TECHNICAL NOTE			
from:	ALAN DAVIES	date:	15/8/022
subject:	Technical Details Consent for proposed residential development of upto 9 dwellings following Permission in Principle application 3/2018/0582 south of Old Road Chatburn 3/2022/0500	file ref:	J1050-TN2

PL 30

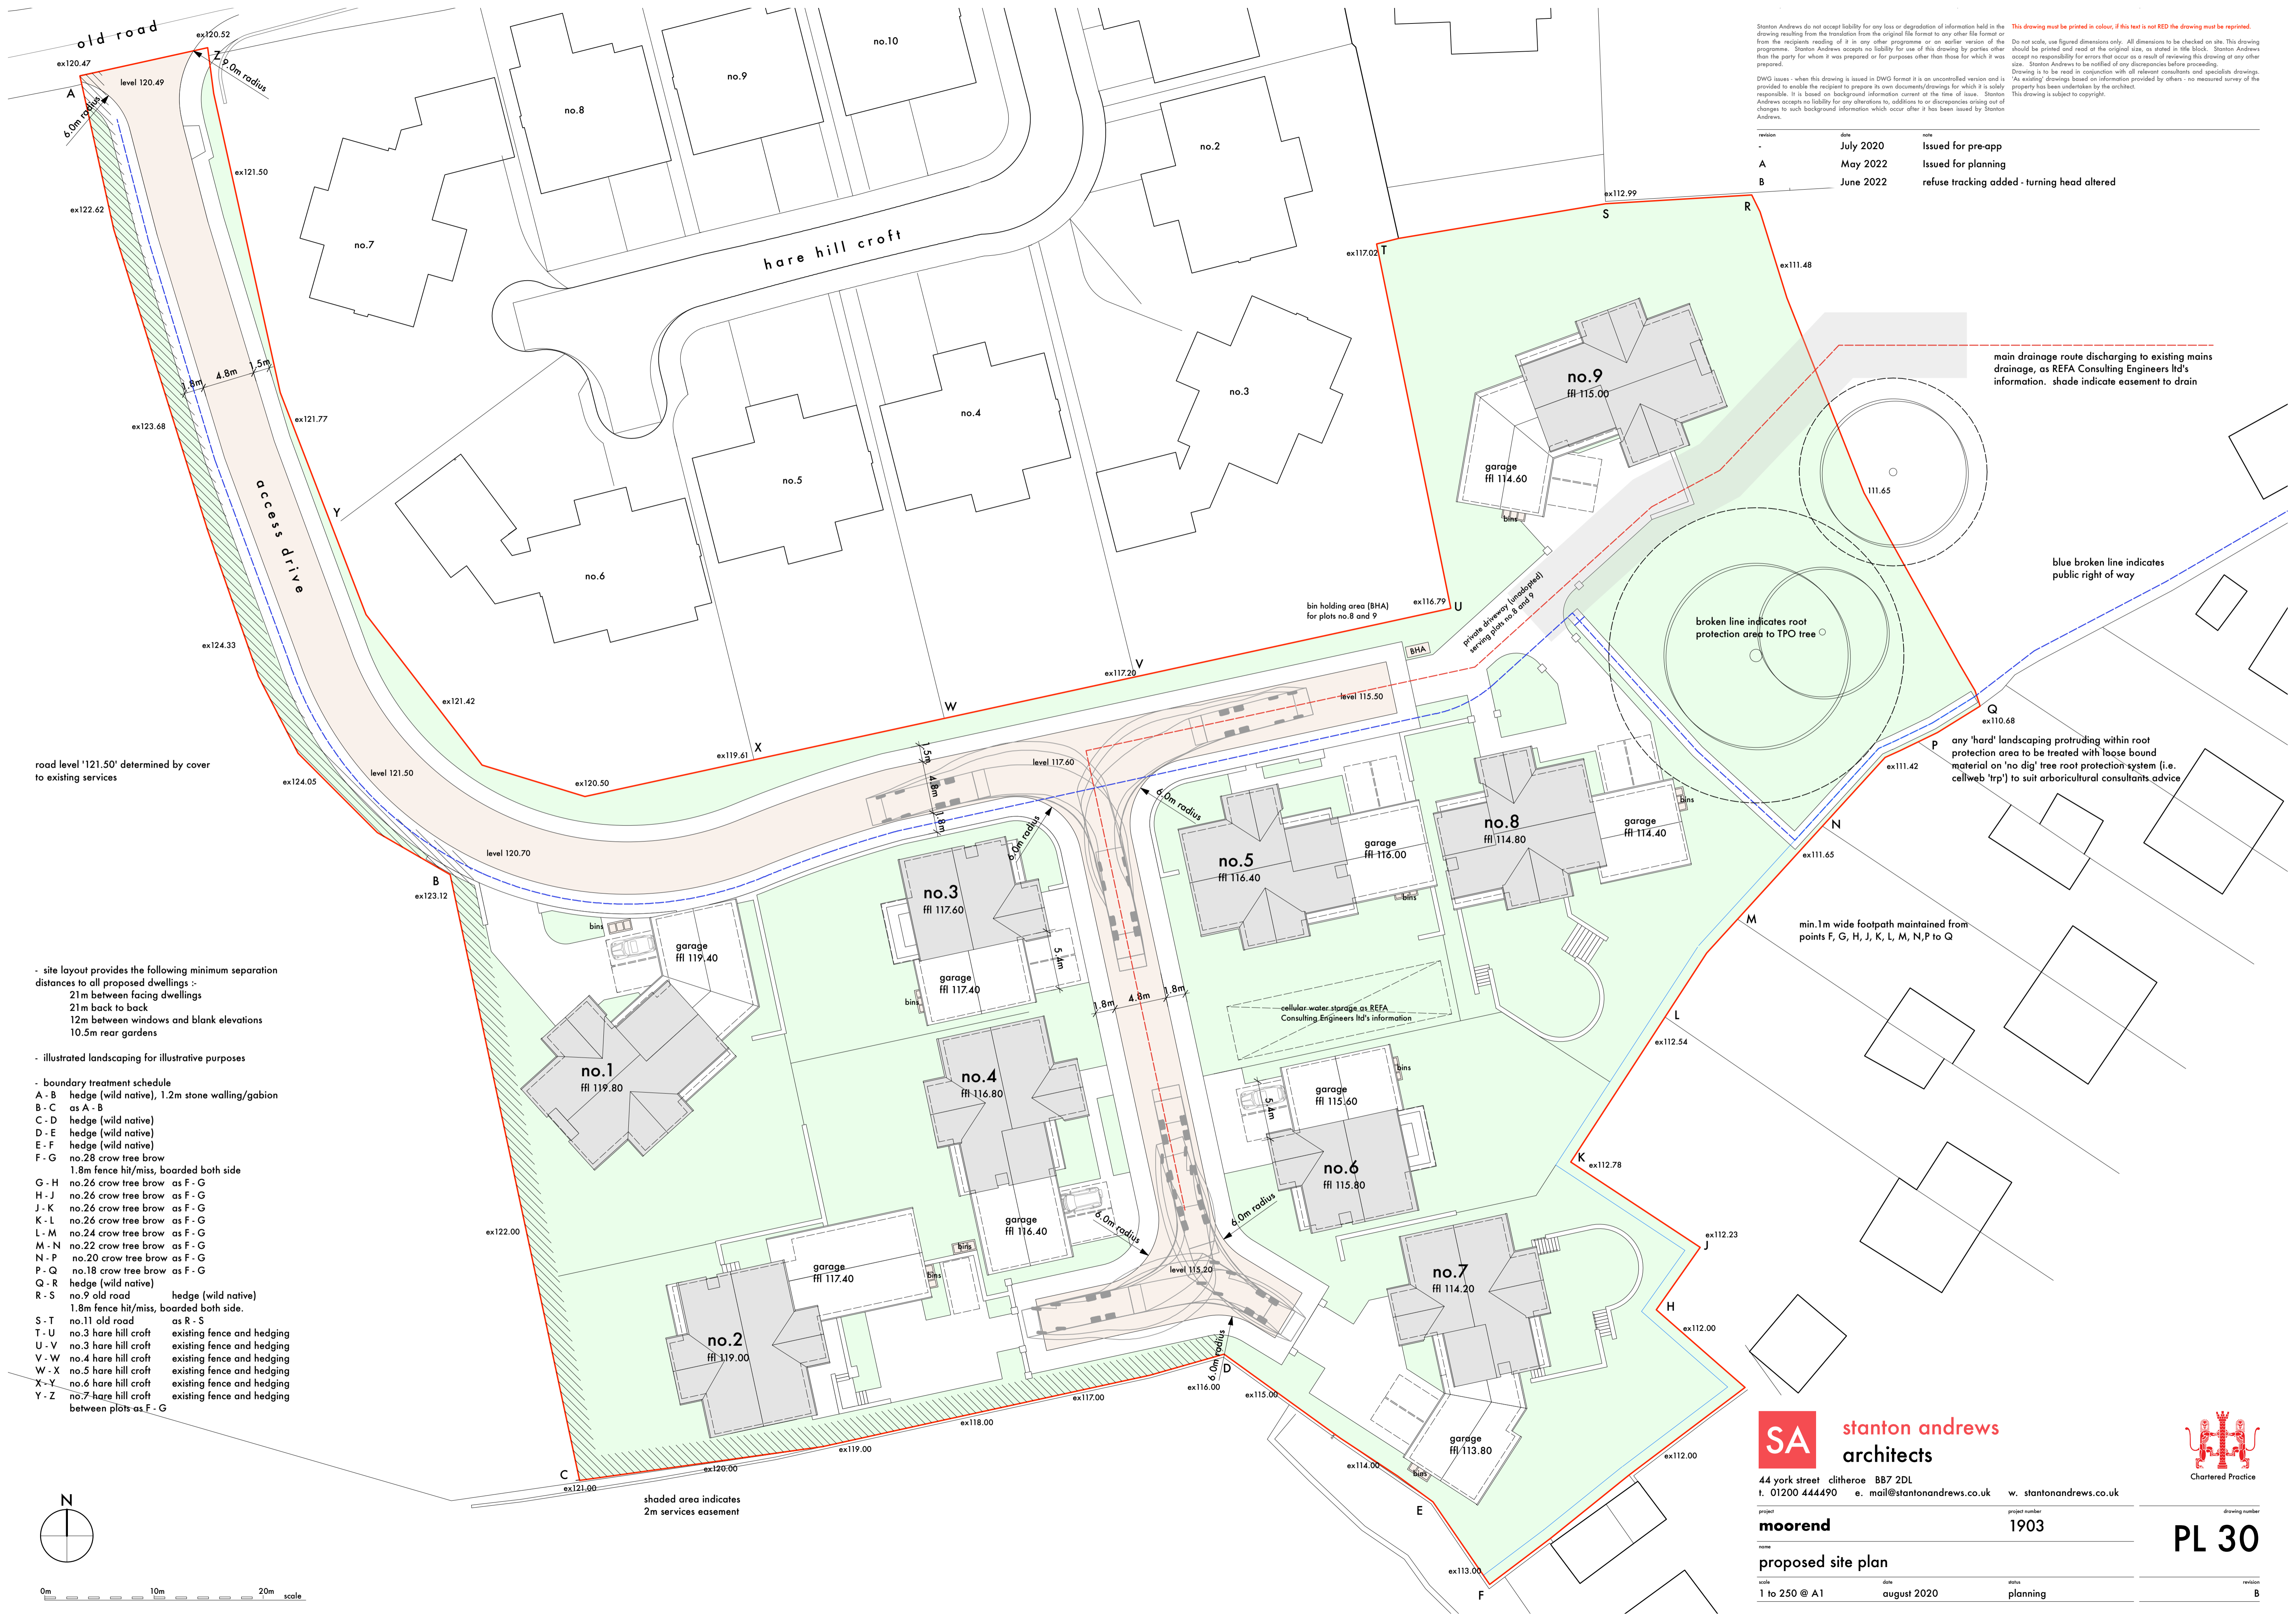
The LHA have reviewed Stanton Andrews drawing number PL30 Rev A titled "Proposed Site Plan" and are aware that the proposed access will have a kerb radii of 6m and 9m. To ensure the kerb radii is adequate for refuse vehicles a swept path analysis drawing is required showing the refuse vehicle entering and exiting the site.

The swept path analysis drawing will also allow the LHA to assess whether the access width is adequate for two-movements to occur when a large vehicle is using the access.

To ensure that the minimum width of the carriageway and the layout is adequate, a swept path analysis drawing showing a refuse vehicle using the internal layout is required. The drawing should also show how the refuse vehicle will use the turning head to exit the site in a forward gear.

The LHA have reviewed Stanton Andrews drawing number PL30 Rev A titled "Proposed Site Plan" and are aware that there are grass verges at the back of the footway.

The LHA require the private access track serving Plots 8 and 9 to provide an access track measuring a minimum of 4.25m wide for the duration of its length. The track should also be adequately surfaced.

The LHA also advise the Applicant that a bin collection point for the Plots is required. This should be located outside of the junction's visibility splays and only be used during bin collection days due to refuse vehicles unable to access private tracks.

However, the LHA require amendments to be made to Plots 3 and 6 driveways. This is because should two car parking spaces be provided on the driveway, the width of the two combined spaces should measure a minimum of 5.3m given that one of the spaces is bound by the dwelling.

The need for large vehicle access is understood however it has to be noted they are low in number i.e. refuse 1 per week, deliveries worst case 1 per day average thus the norm is car/car in/out.

Surfacing will be part of the hard landscape design, width is 4m in width with inter visibility between two houses as such the need to pass each other is minimal and thus the width is considered adequate.

Noted and outside splays as requested,

Noted and parking updated on drawing with measurement set out.
